From: Maria Tomalova
Sent: 19 July 2019 10:52
To: Planning.Responses
Subject: FW: BR/63/19/PL, 15-17 Kew Gardens, Bognor Regis
Attachments: 180037_02B_blockplan-A3 SHEET.pdf; 180037_03A_proposedsiteplan-A1 SHEET.pdf; 180037_04A_proposedplansandelevationsP1andP2-A1 SHEET.pdf; 180037_05A_proposedstreetscenes-A1 SHEET.pdf; 180037_07_proposedplansandelevationsP3andP4-A1 SHEET.pdf; 180037_08_proposedplansandelevationsP5andP6-A1 SHEET.pdf

Technical housing standards – nationally described space standard

Title:-
Proposed Floor Plans & Elevations (P3&P4)

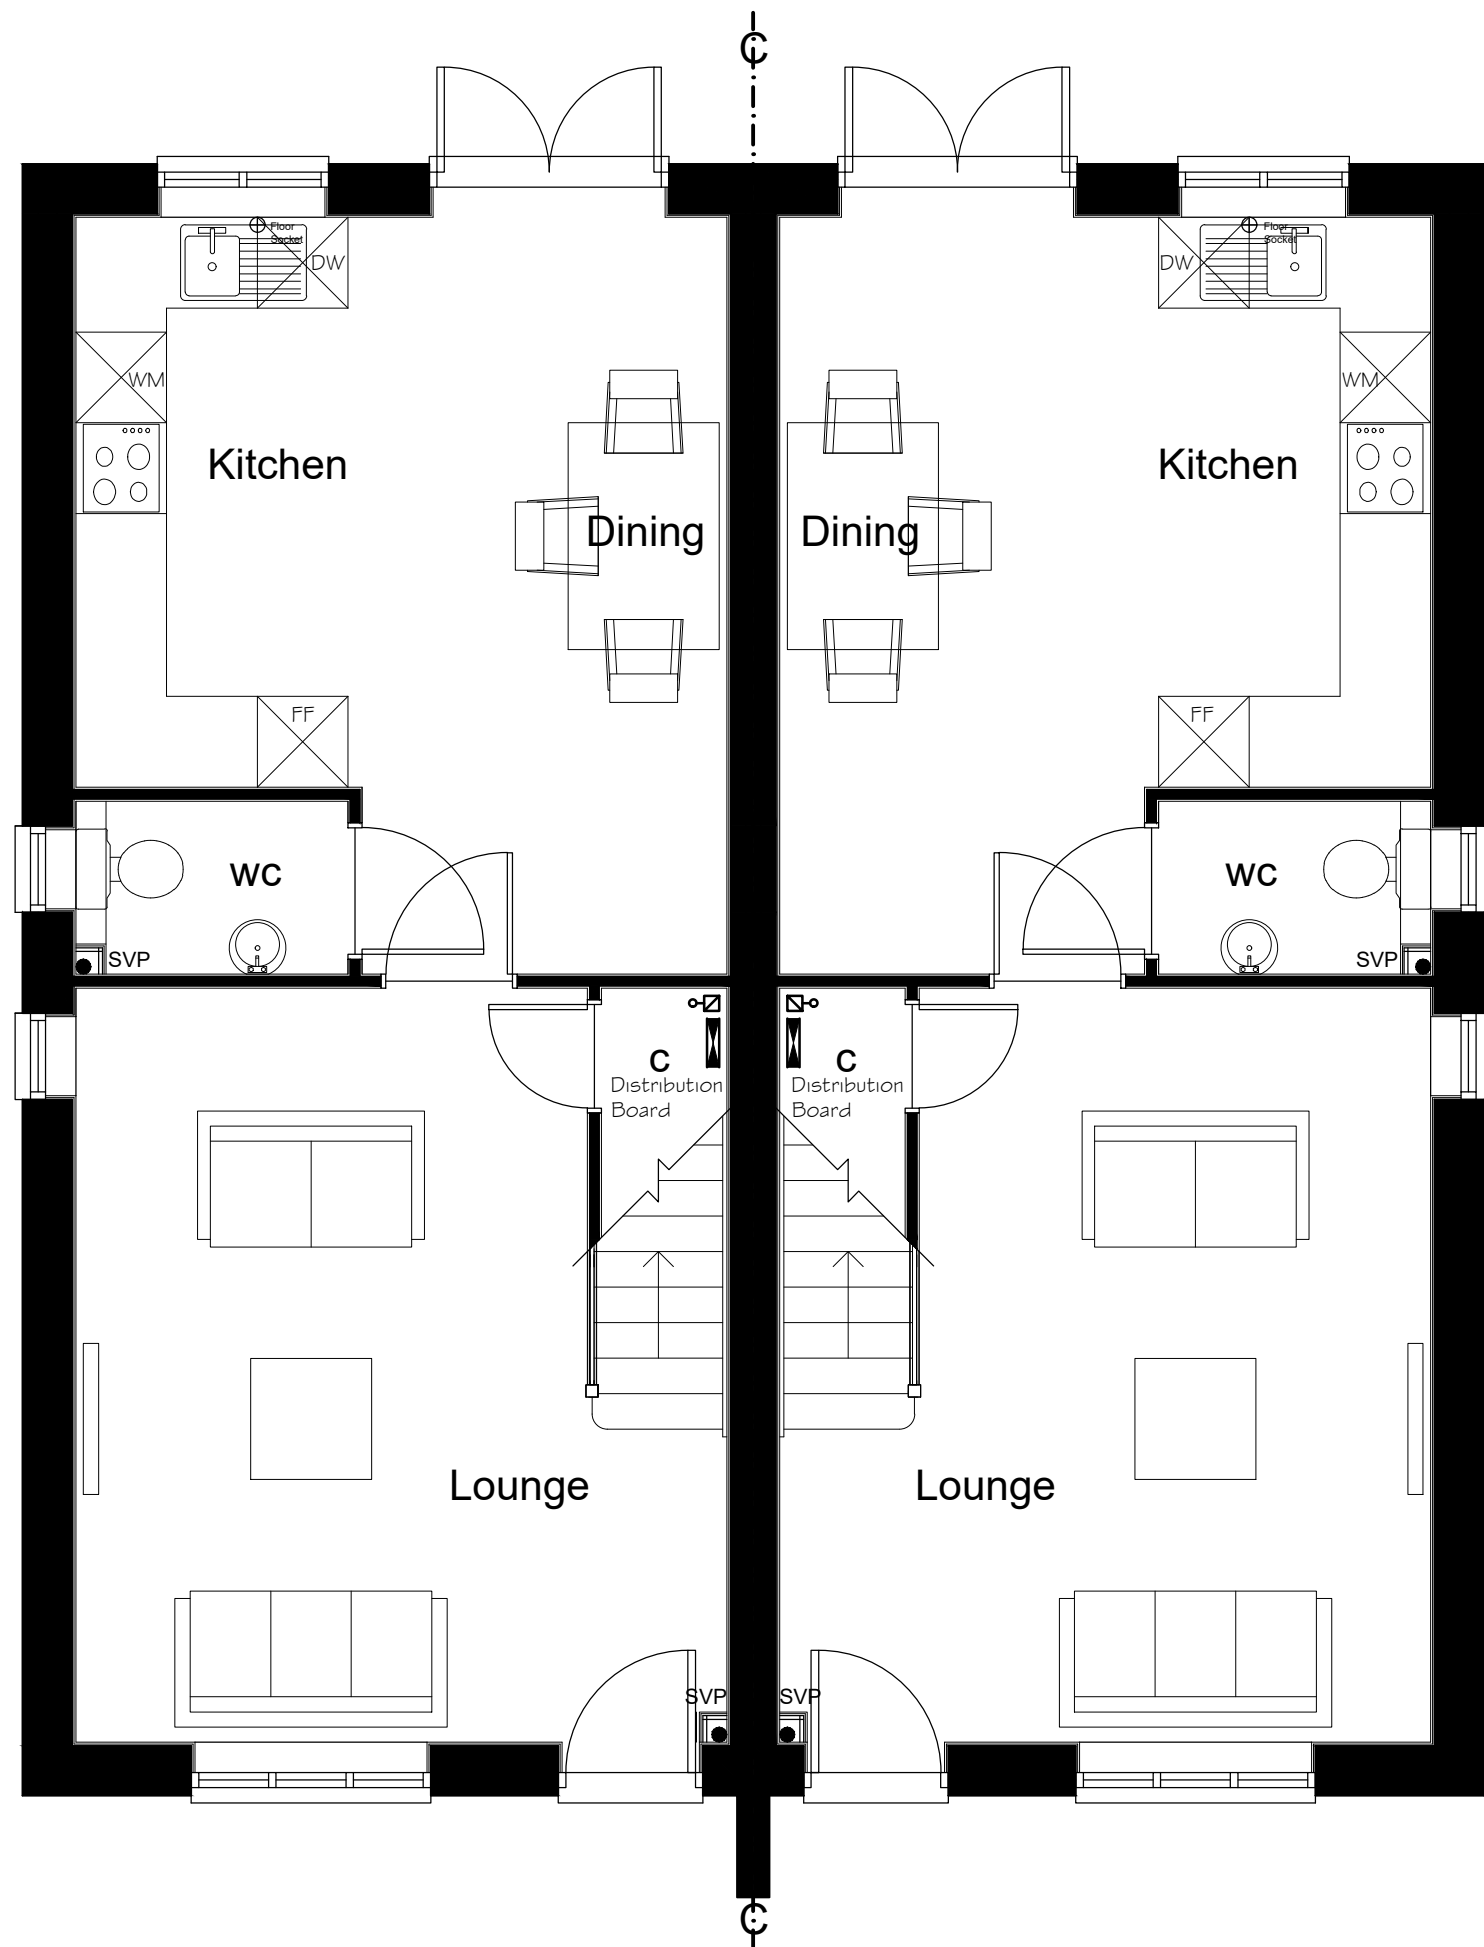
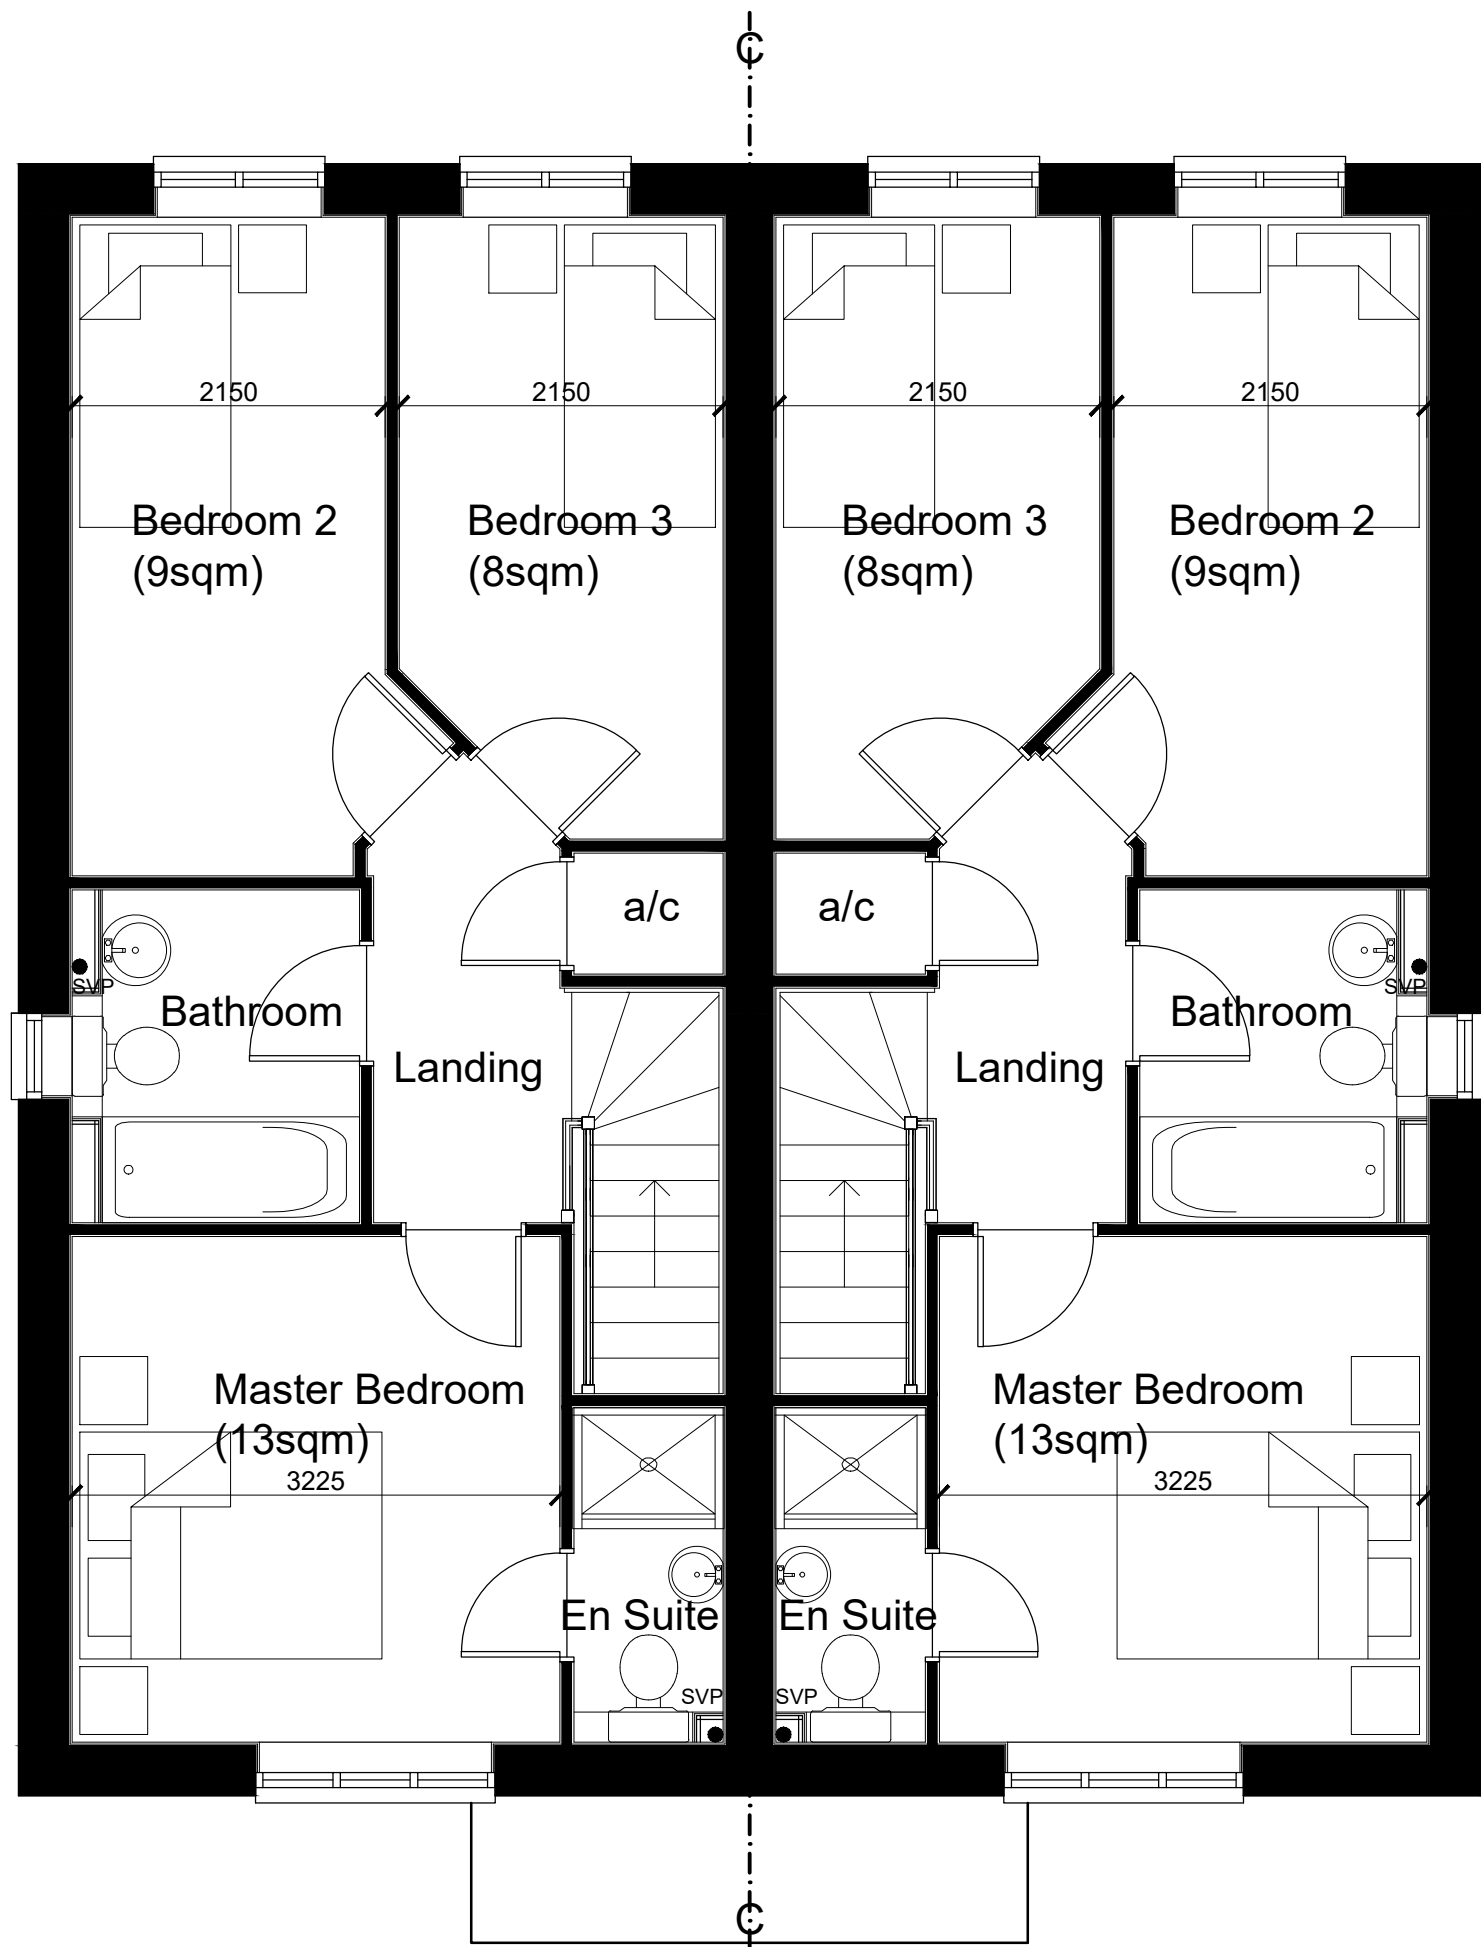
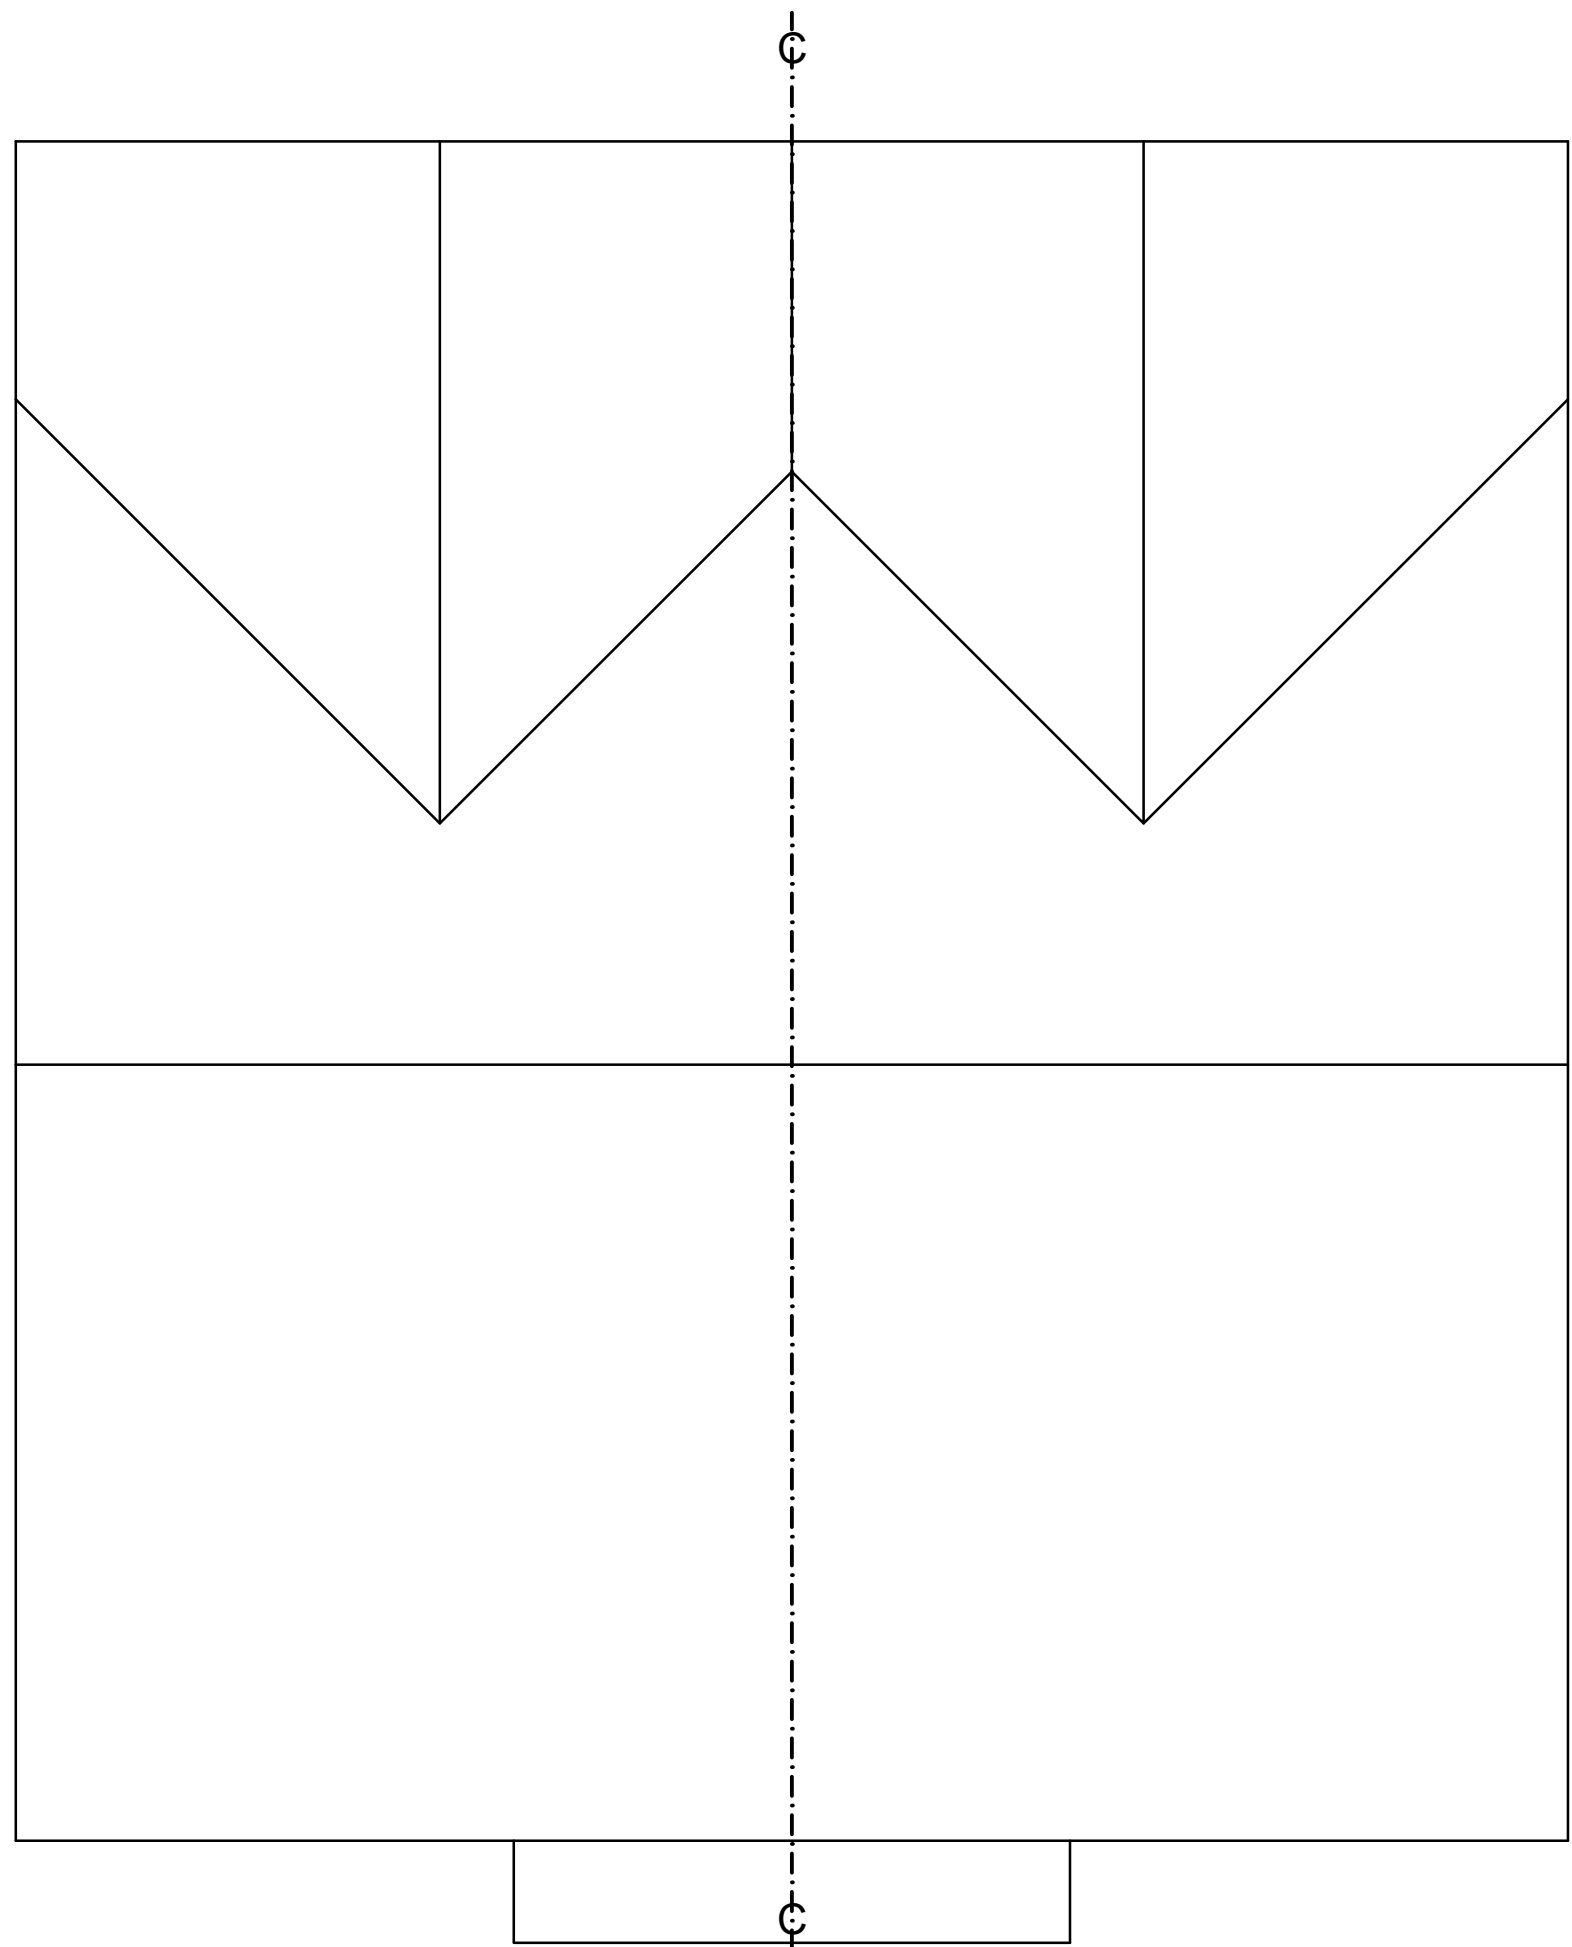
Please see below the min requirement for the floor space.
I am afraid your proposal would not comply with.

- c. in order to provide one bedspace, a single bedroom has a floor area of at least 7.5m² and is at least 2.15m wide
- d. in order to provide two bedspaces, a double (or twin bedroom) has a floor area of at least 11.5m²
- e. one double (or twin bedroom) is at least 2.75m wide and every other double (or twin) bedroom is at least 2.55m wide

3bed, 2storey

min 102 square metres

It is rather difficult to comment your drawings, since I do not have a tool to measure it on the screen
And I am not sure the size of some bedroom comply with the standard (min width 2.15m, min floor space for 1 bed
7.5 square metres.

I confirm that plots 1 and 6 are now 2 bed 3 person houses at 72sqm. Plots 2 and 5 are now 2 bed 4 person houses at 81sqm. Plots 3 and 4 are now 3 bed 4 person houses at 87sqm. All the bedroom areas and widths now all comply. On this basis all units now comply with the standards.
